County File: OAR2355  
City of Fountain File: ODP-23-003  
Re: Corvallis Overall Development Plan Amendment No. 1  
To: Kristy Martinez, Planning Supervisor

Engineering has the following comments on this Final Plat and Final Drainage Report (documents dated 2023-2024), mainly regarding effects of drainage on offsite adjacent unincorporated County areas.

## FINAL PLAT

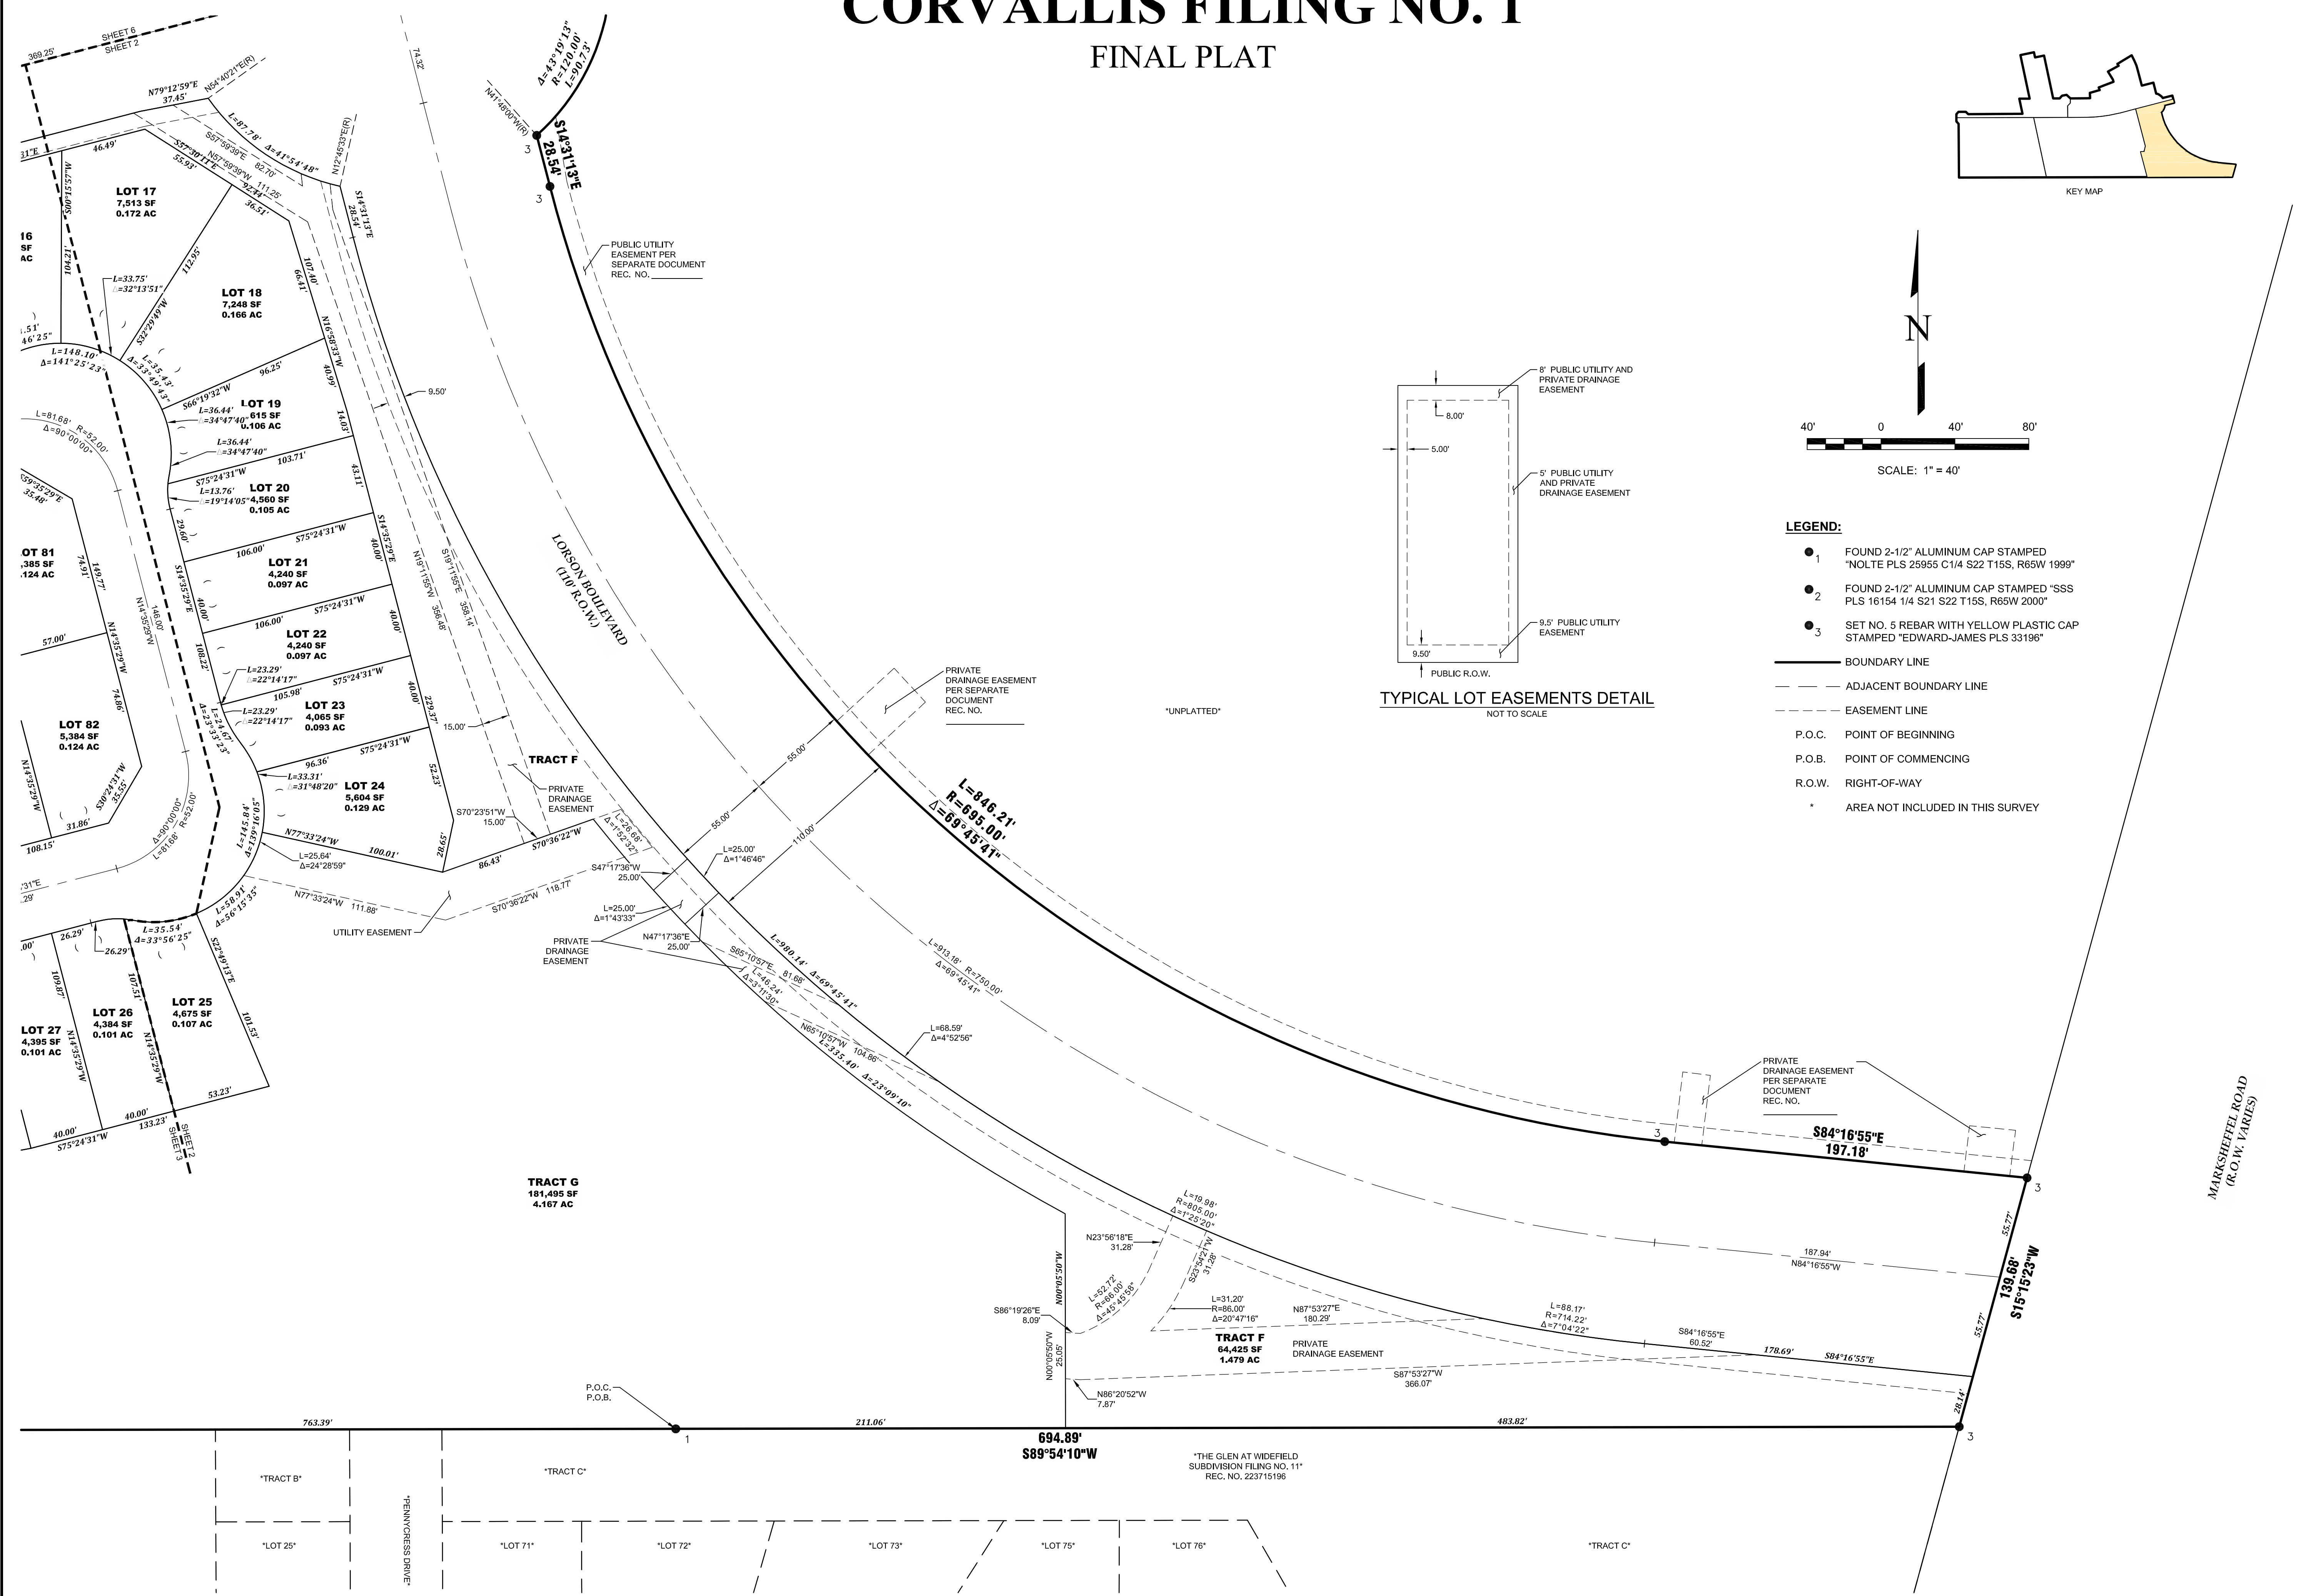
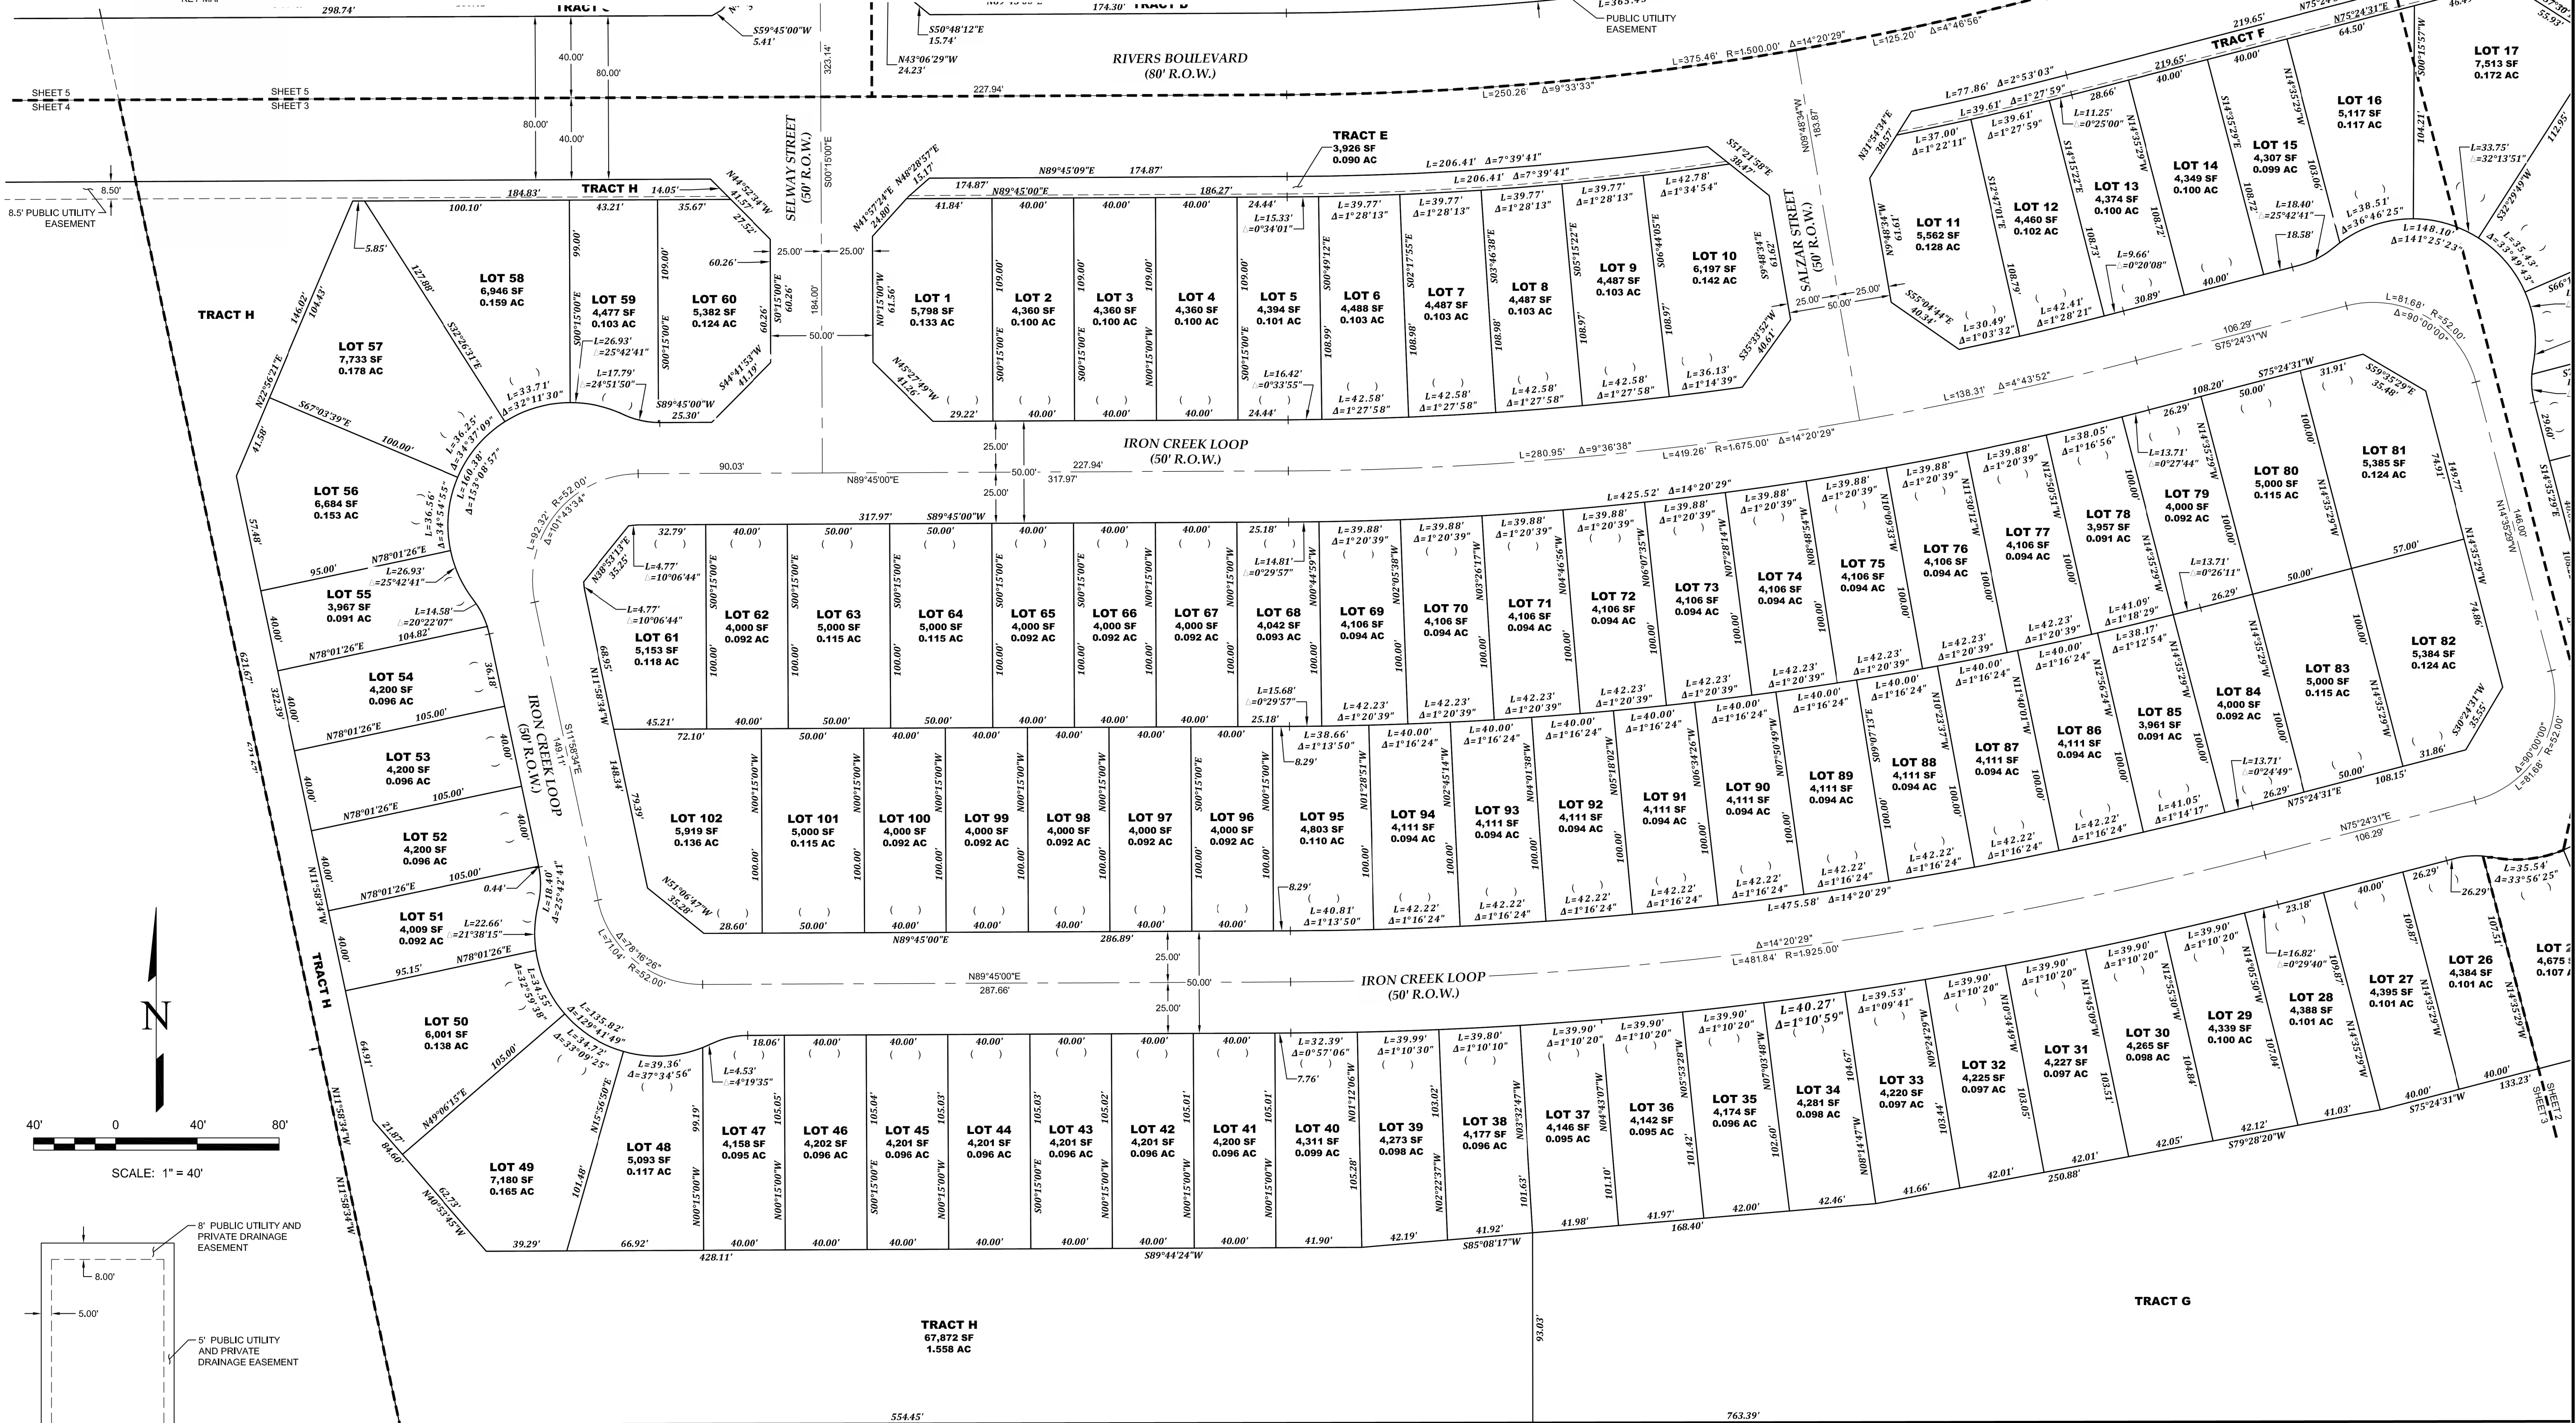
- See drainage plan redlines. (Adjust CDs accordingly.)
- See plat redlines regarding tract label.
